# A1 in Northumberland: Morpeth to Ellingham

**Scheme Number: TR010059**

## 7.19 Change Request Letter

## **A1 in Northumberland: Morpeth to Ellingham – Material Change request**

Indicative Earthwork Change Locations

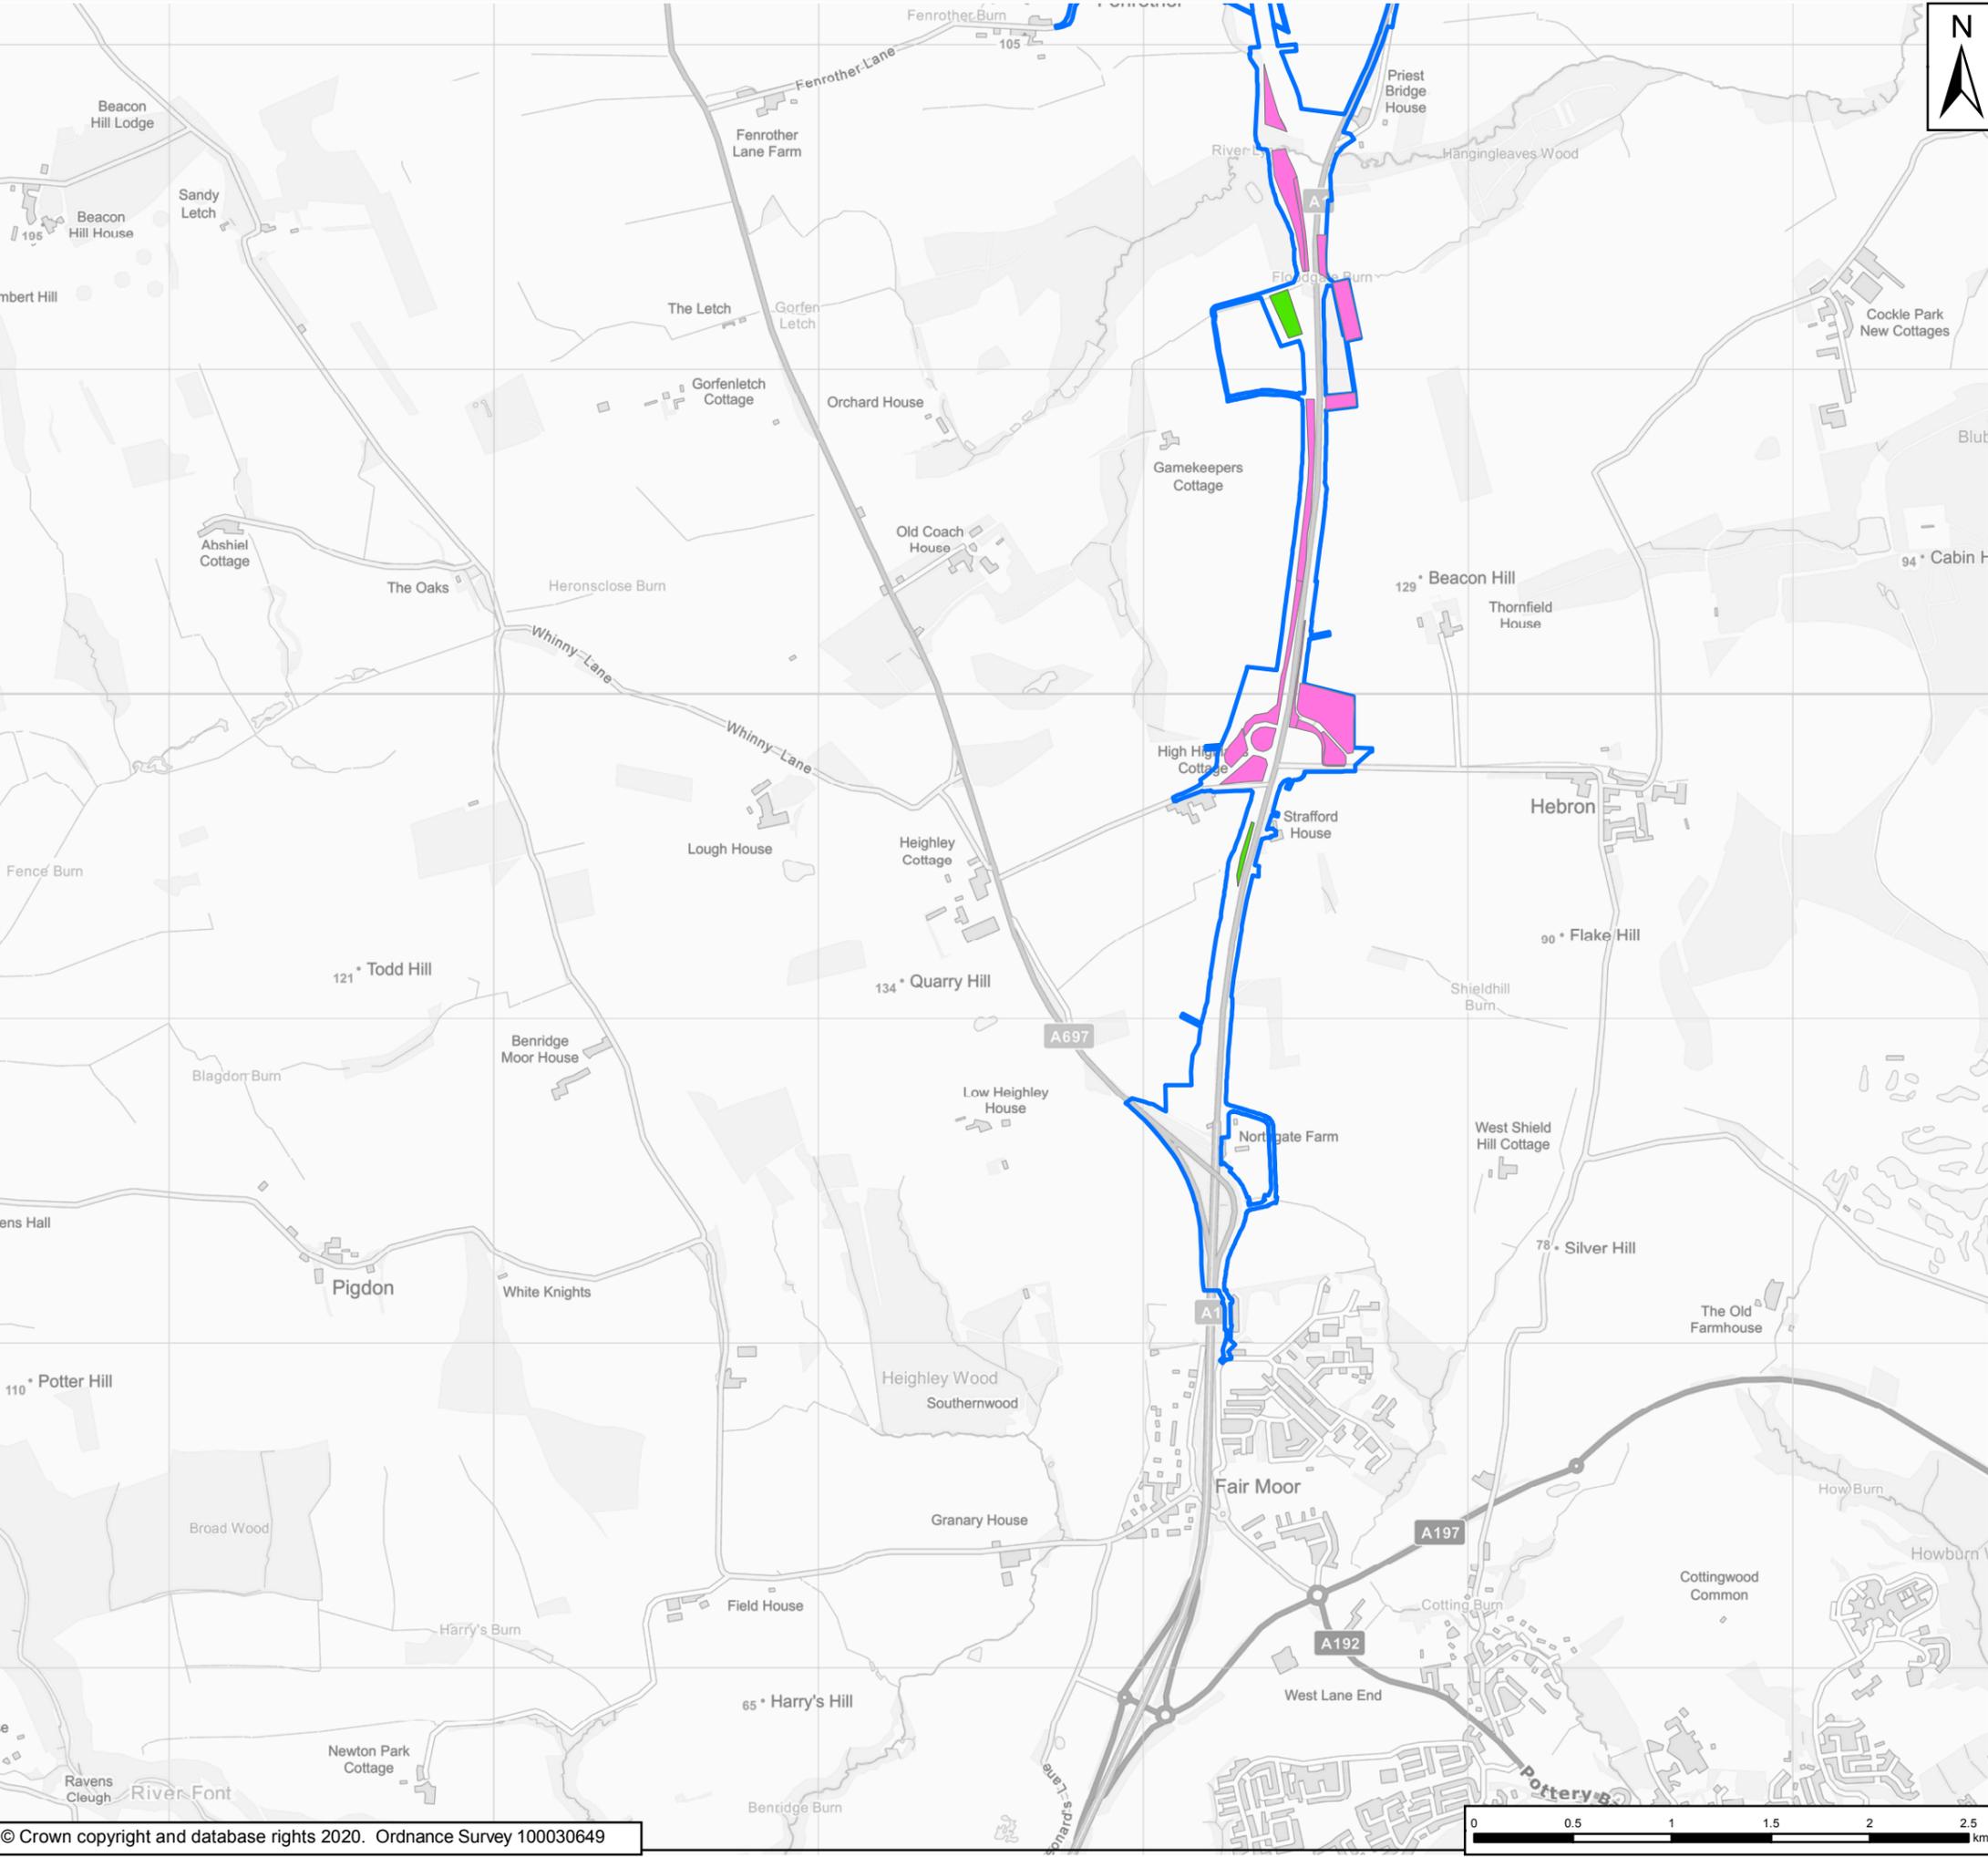
Changes to temporary and permanent earthworks within the Order limits along both Part A (Morpeth and Felton) and Part B (Alnwick and Ellingham) in order to reduce earthwork movement. The Earthwork Amendments would consist of the following:

- a. Utilising borrow pits in Part B to exchange and win additional material suitable for construction.
- b. Maximising use of soil bunds already specified in the Figure 7.8: Landscape Mitigation Masterplan Part A [REP3-008], Figure 7.10 Landscape Mitigation Plan Part B [APP-144] and Figure 7.14: Landscape Mitigation Plan including Assessment Parameter 3 for Part B [APP-148], for disposal of excess site material, in Part A.

- c. Maximising of fill within slopes, already specified within Figure 7.8: Landscape Mitigation Masterplan Part A [REP3-008], Figure 7.10 Landscape Mitigation Plan Part B [APP-144] and Figure 7.14: Landscape Mitigation Plan including Assessment Parameter 3 for Part B [APP-148], for re-use of site material, in Part A.

- d. Creation of new soil bunds in Part B to maximise re-use of excess site material.
- e. Maximising of slopes for re-use of excess Site material, in Part B.

- f. Laying down additional material and increasing some localised ground levels.
- g. Raising levels of junction "bowls" (level or rounded rather than dished).

- h. Creating new, temporary soil storage areas in both Part A and Part B.

Permanent Works at the River Coquet

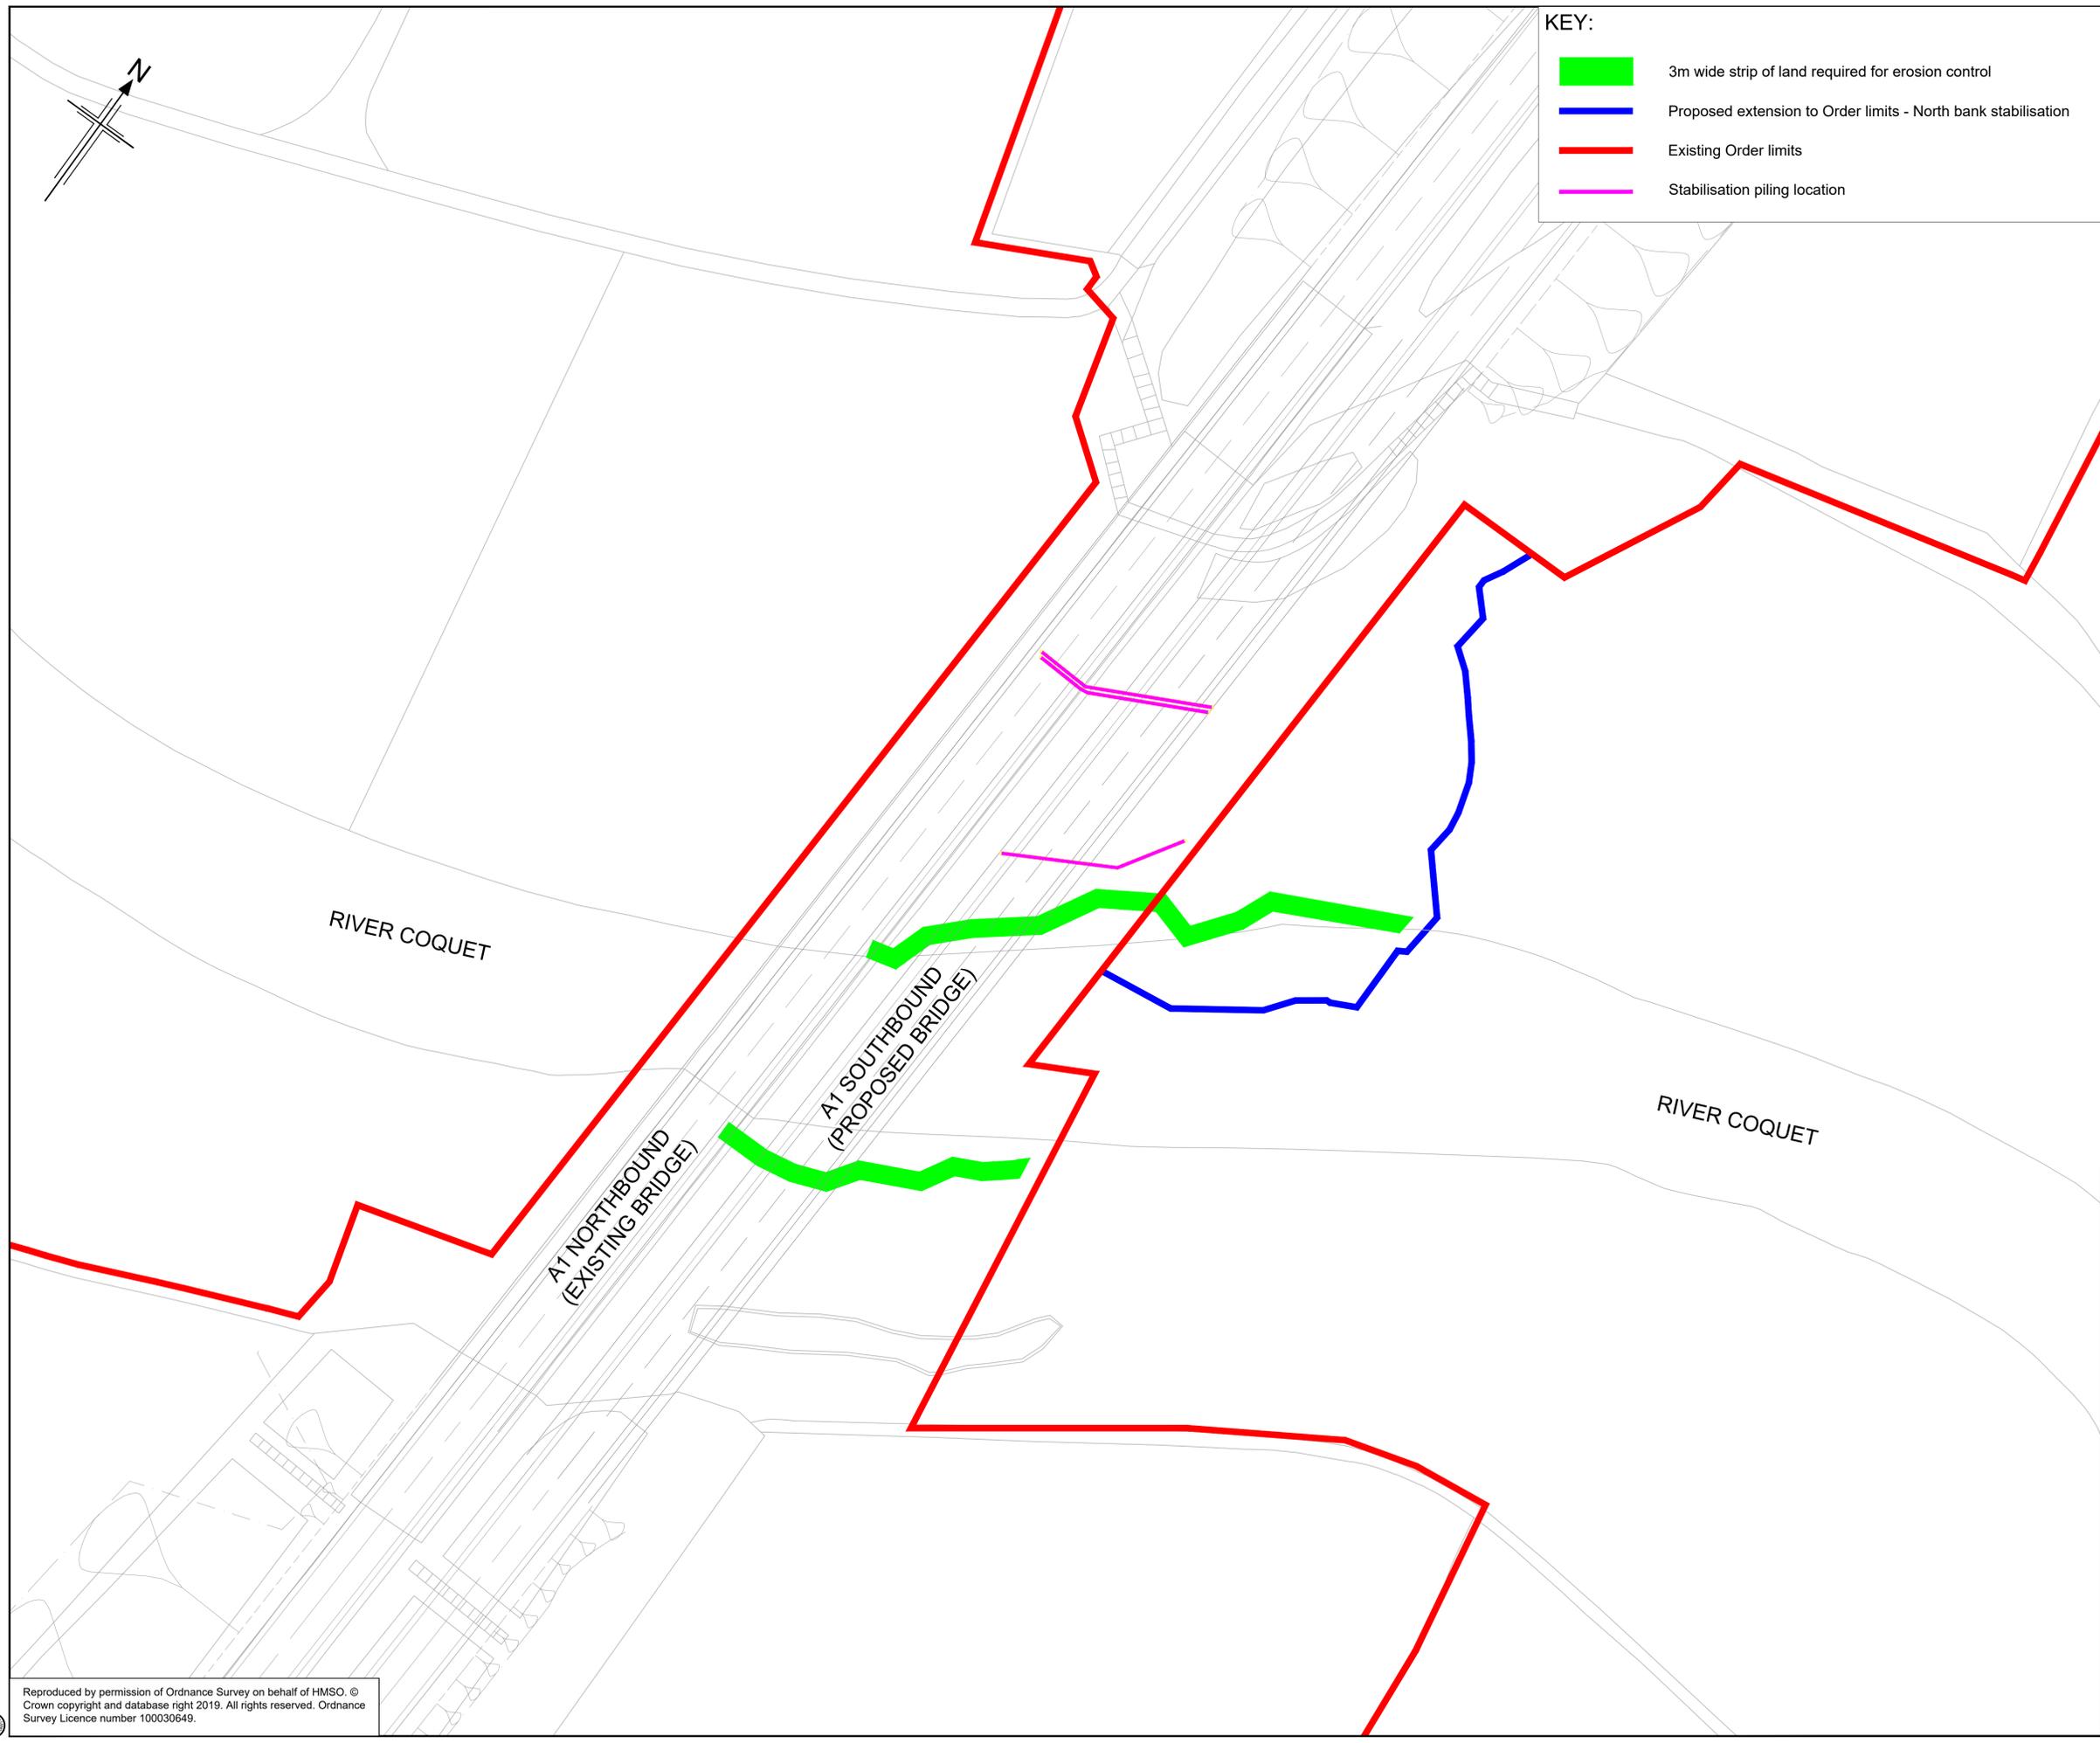
The Stabilisation Works include works on the north bank of the River Coquet in order to stabilise the proposed bridge and existing bridge within Part A. The works would consist of the following:

- a. The installation of three rows of piles in the north bank of the River Coquet, which would require the Order limits to be extended;
- b. The installation of temporary river training and permanent erosion protection measures on the north bank;
- c. A total of 0.28 ha of land outside the existing Order limits of Part A would be required as a working area for the installation of the piles and access to works, as well as for the carrying

It has been determined that there is a requirement to temporarily install temporary river training works to permit the piling platform to be formed and, to protect the bridge foundations from hydraulic action, scour protection measures are required to maintain the integrity of the proposed design. The scour protection would extend beyond the existing Order limits of Part A, requiring an extension to the Order limits.

In order to stabilise the proposed bridge and existing bridge within Part A, the proposed solution is that it would comprise spaced bored piles, ensuring the stability of the northern valley sides and allowing new pier foundations to be installed.

The Applicant has determined that in light of the assessed bank river velocities likely to be experienced there is a requirement to protect the bridge foundations from hydraulic action and that scour protection measures are required to maintain the integrity of the proposed design. The Stabilisation Works on the slope would, therefore, include scour protection along the river's edge on the north bank of the River Coquet to provide erosion protection to
